Planning application reference: 2020/90367

I am writing to object to the planning application 2020/90367 at 111 Marsh Lane, Shepley, on the following grounds:

title outline sketch plan proposal
number 19084D-02-P04
scale 1:200
size A1

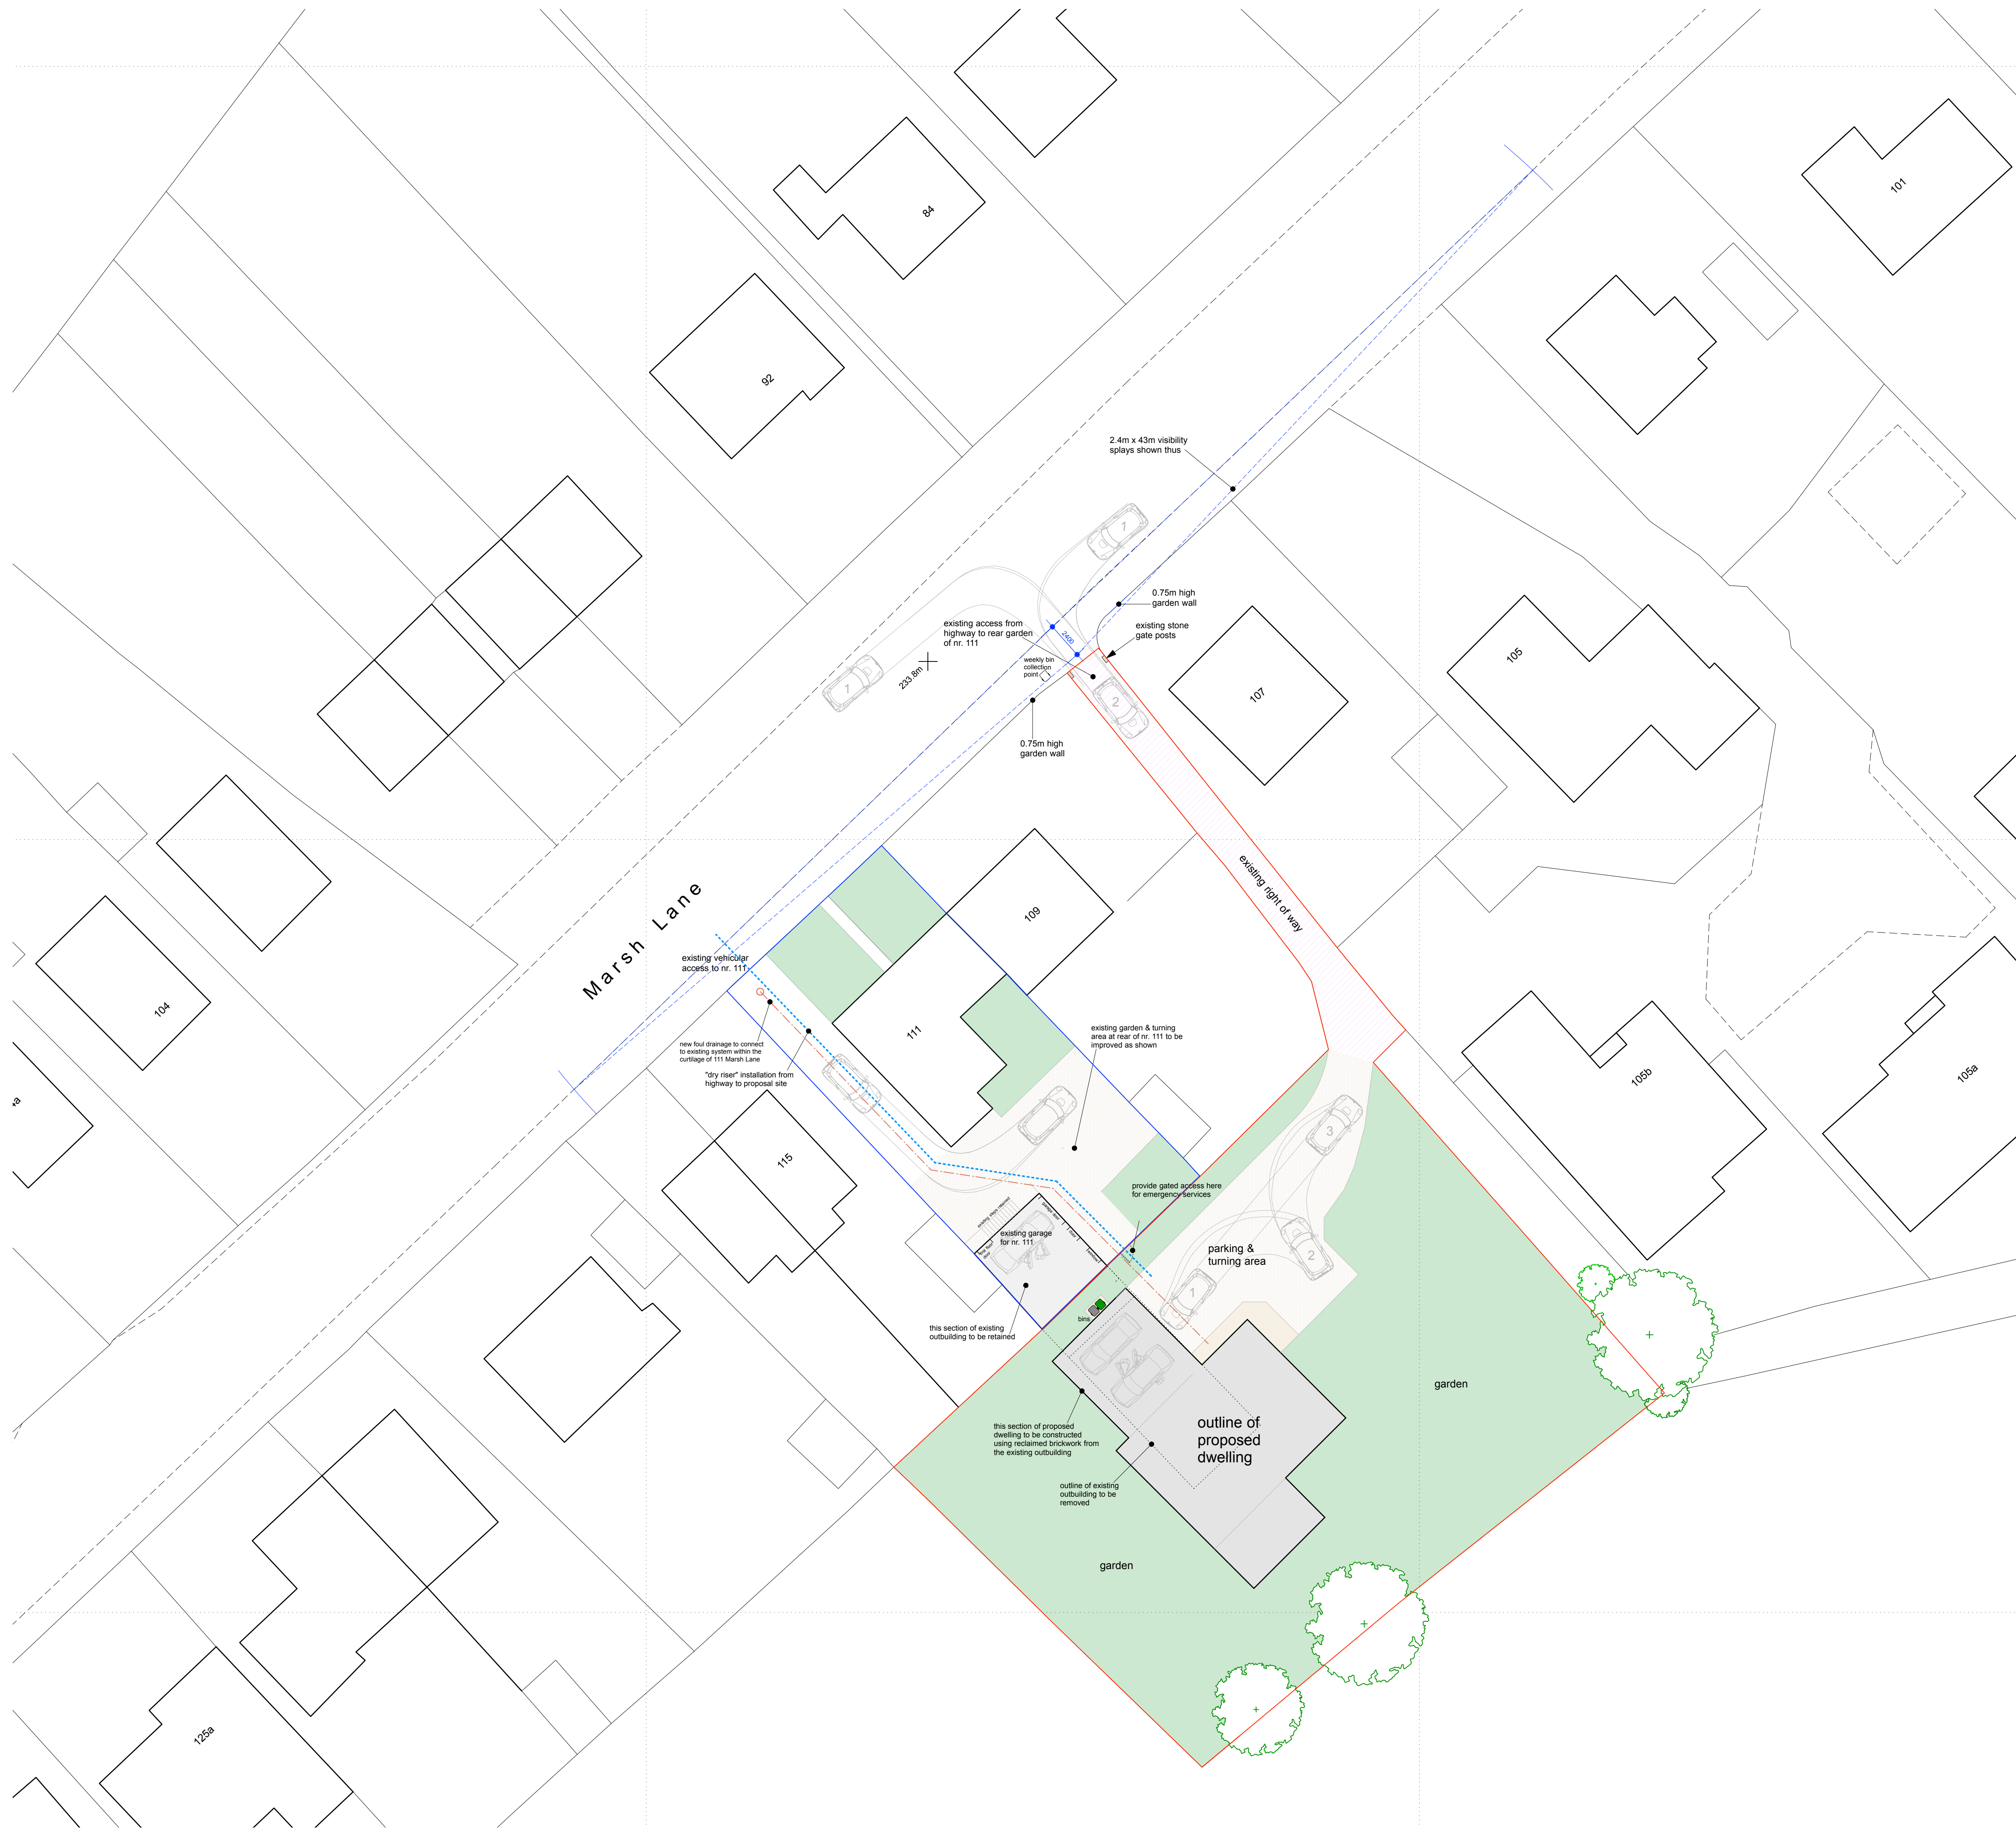
There are currently no houses at the rear of Nos. 111 to 127 Marsh Lane. The proposed 4+ bedroom house at the rear of 111 Marsh Lane would overlook all of these properties and lead to a loss of privacy. I am concerned particularly for my own house and would be potentially dwarfed by the new build house at the rear of 111. The proposed orientation of the new house would mean that windows at the rear and side of the proposed house also seems too close to existing houses.

The proposed access points at the side of 109 Marsh Lane and also along the existing driveway at 111 are too narrow and therefore not suitable for large and emergency vehicles such as fire engines.
